From: Ross Leal
Sent: 16 January 2018 10:42
To: Planning.Responses
Subject: FW: 28 North Lane, EP - EP/156/17/HH

ARUN DISTRICT COUNCIL EP/156/17/HH

GROUND FLOOR PLAN 1:50 @ A3

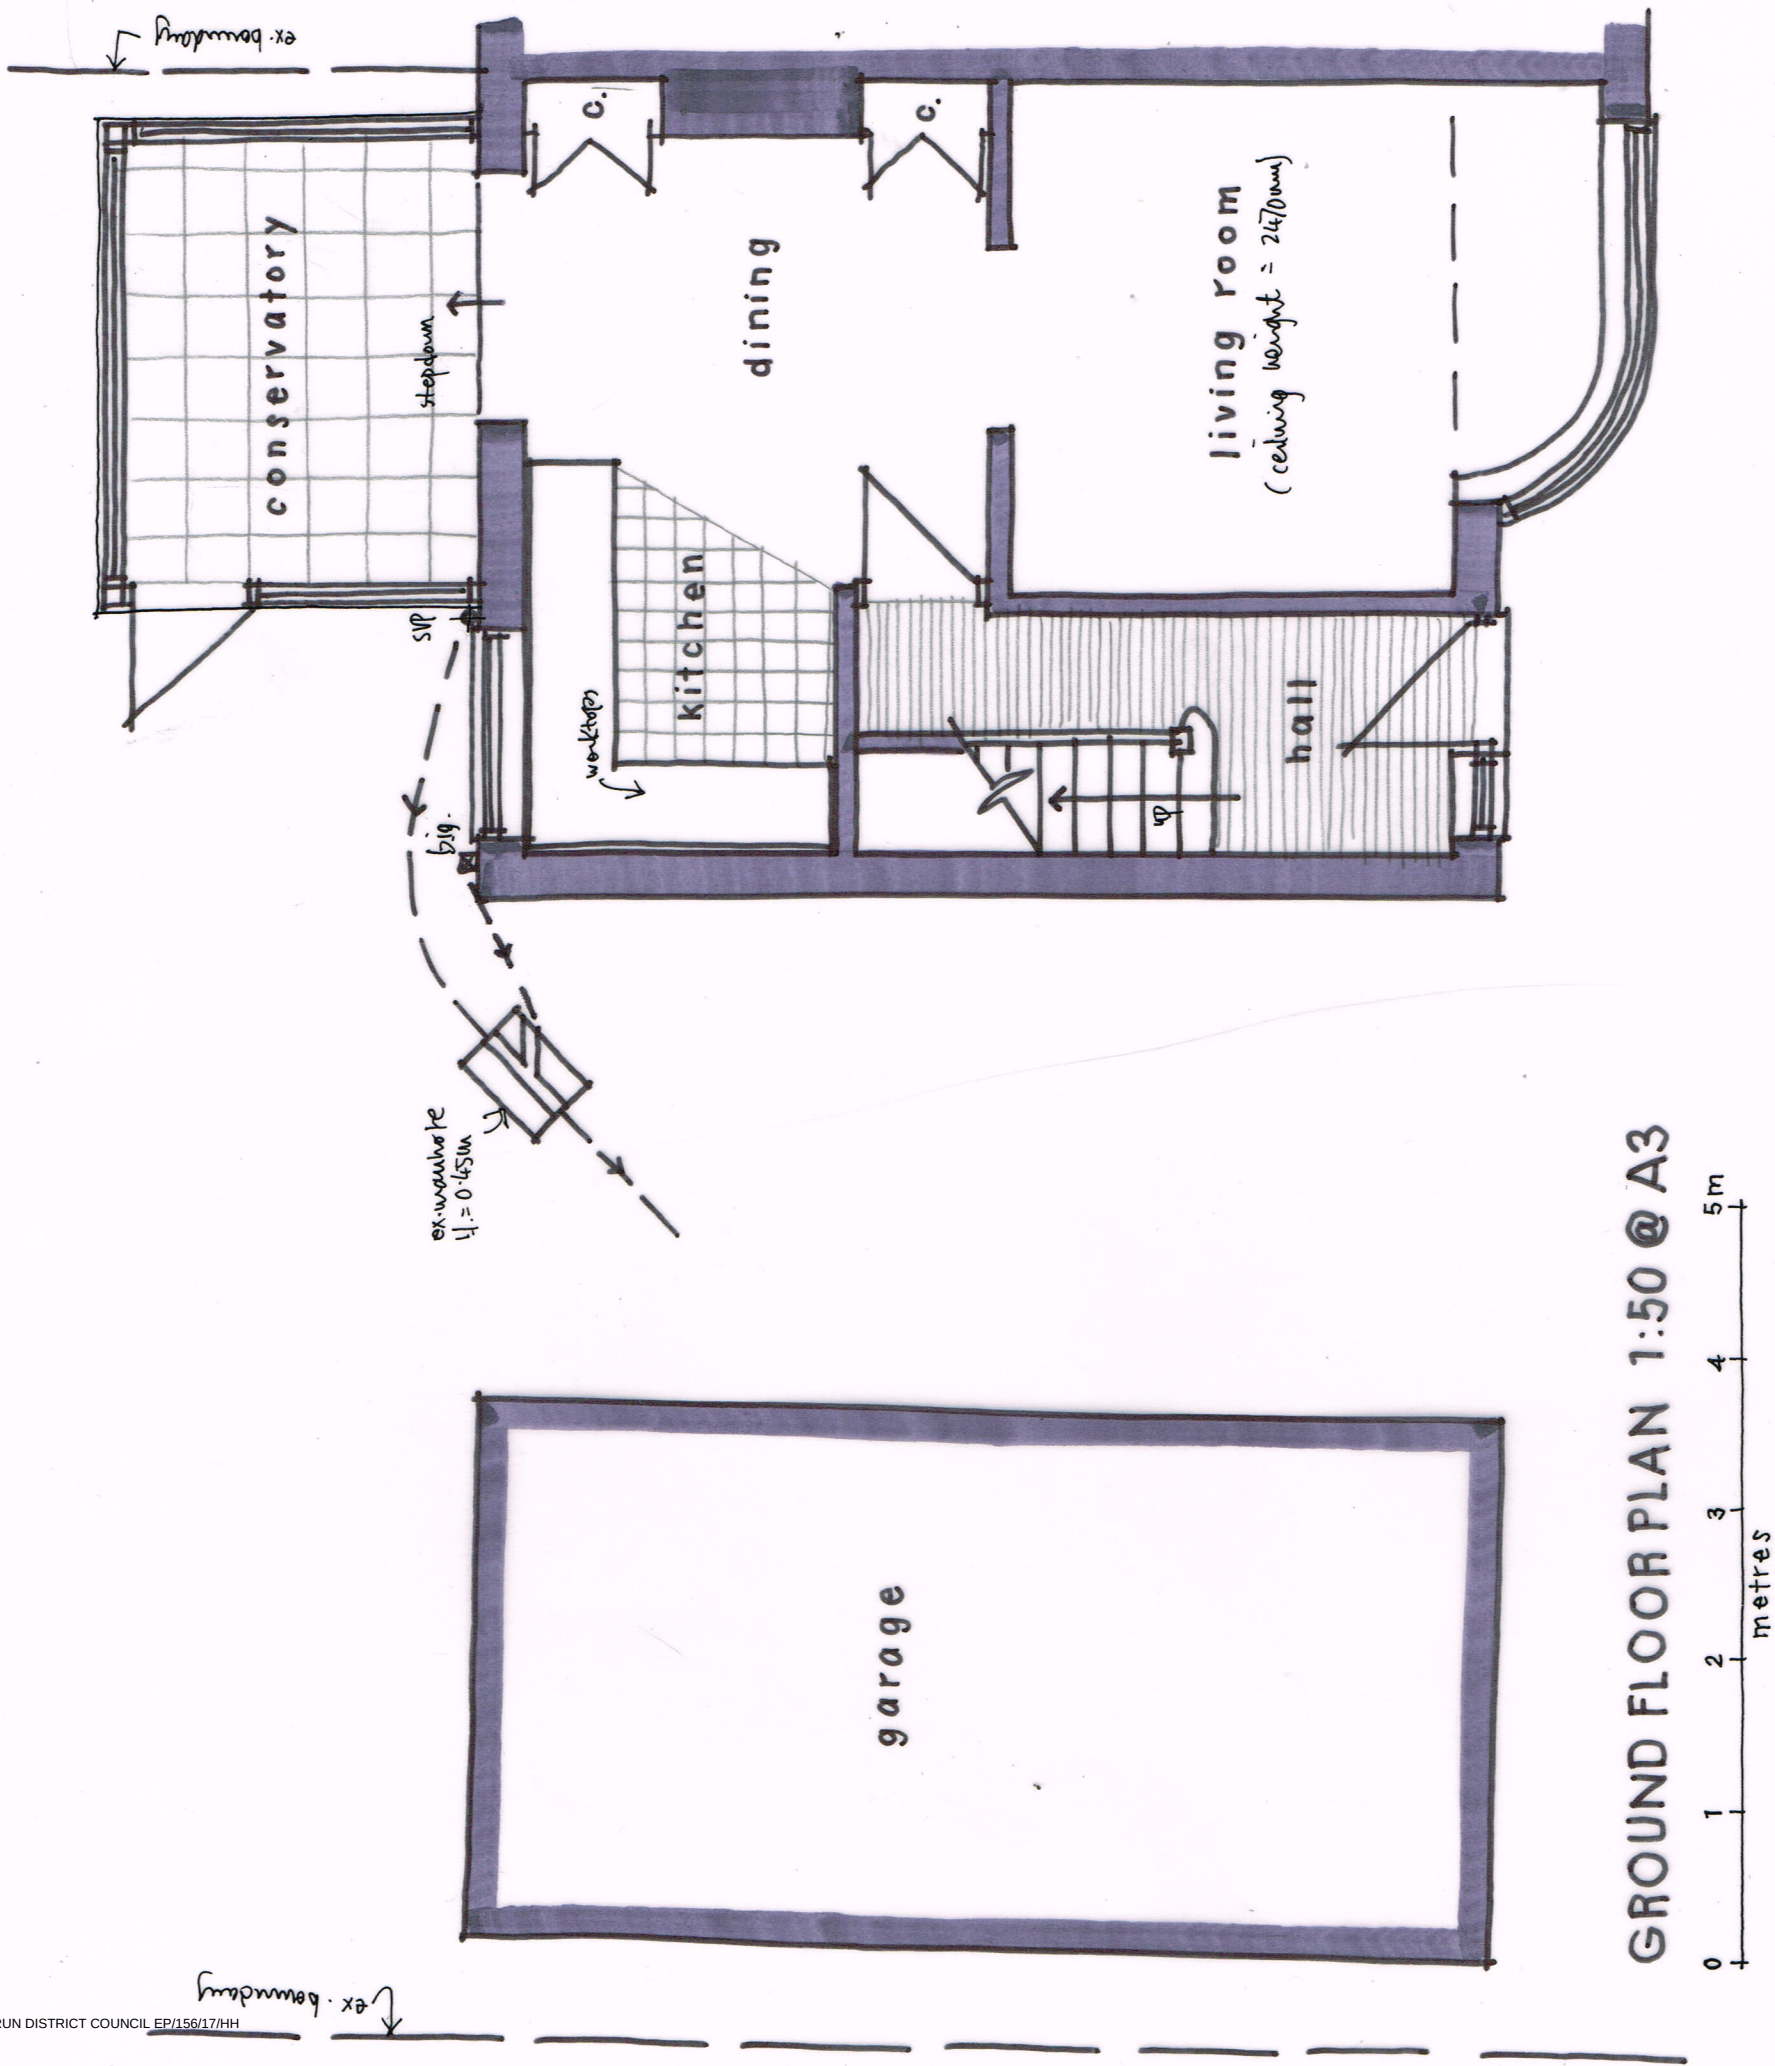
Hi Ross,
45 degree angle shown on the GF extension.
Regards.
Wayne
